**Your Ref:** OWPC17932  
**Our Ref:** EP/29/18/HH 01-03-2018  
**Please ask for:**  
Zac Denton

Rooms in roof with hips to gables & front & rear extension  
Glenian The Street East Preston

Thank you for your internet representation made on 17th April 2018 which has been recorded as '**an objection**' with the comments as follows:

Existing Rear Elevation

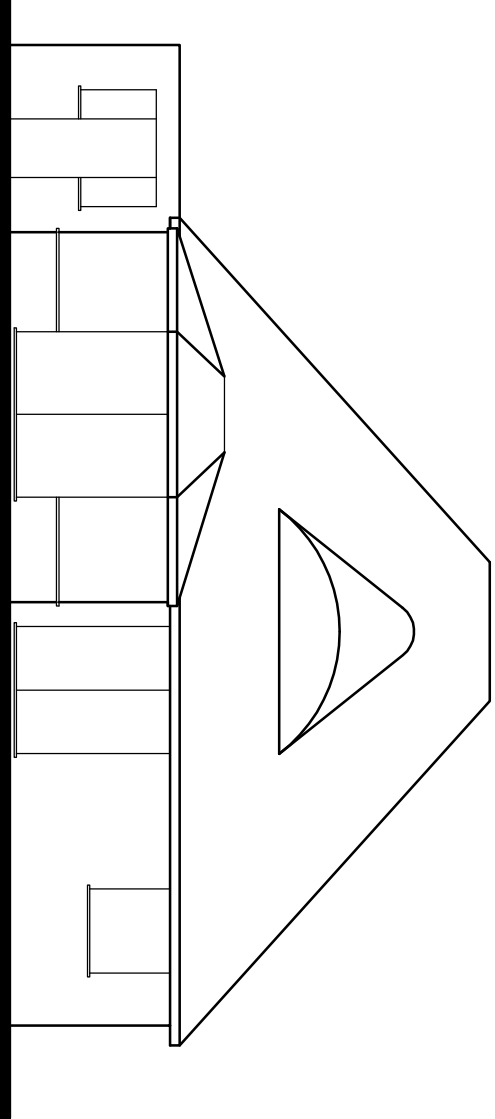
*Also as can be seen from the submitted "Site and other plans" document, there is an interesting original feature "eyebrow" dormer window on the rear elevation to illuminate the existing uninhabited loft space. This would be lost and replaced with a mundane full length flat roofed projection.*

Proposed Rear Elevation

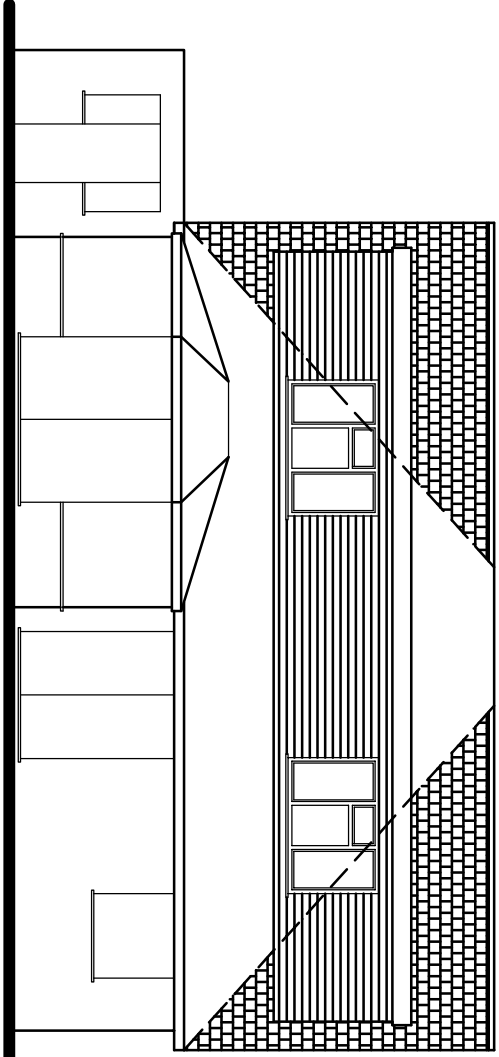
*The resulting two large first floor windows would have direct views over the surrounding gardens, patios and conservatories and remove the sense of privacy previously enjoyed. Unfortunately any partial cover that would be provided by existing trees along the rear boundary, can not be relied upon long term, as several of them are already deteriorating due to age.*

Proposed Front Elevation

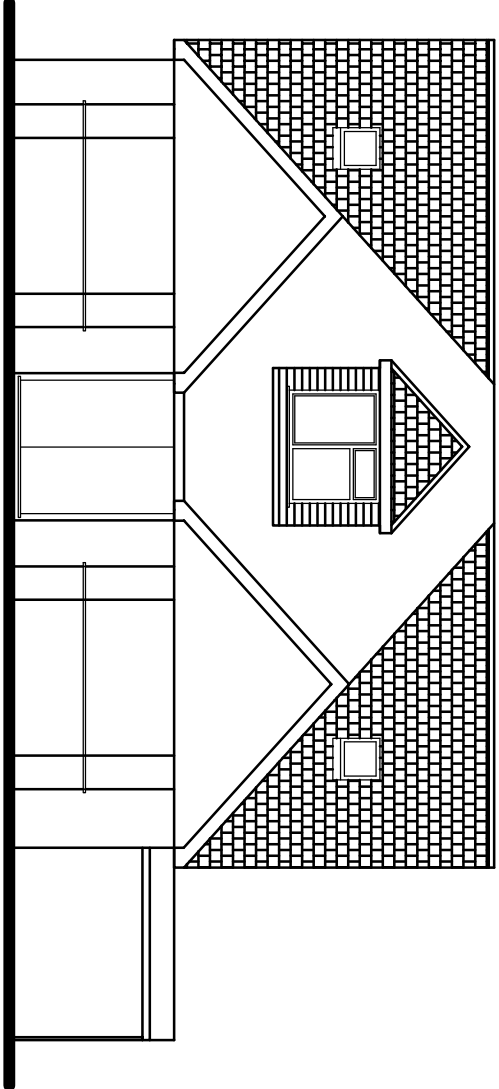
*The proposed alterations would greatly affect the character of the building by almost doubling the visible roof area when seen from the front and rear elevations. They will also be out of keeping with the surrounding dwellings which have been largely unaltered for many years, and are still mostly "genuine" bungalows, especially those to the rear.*
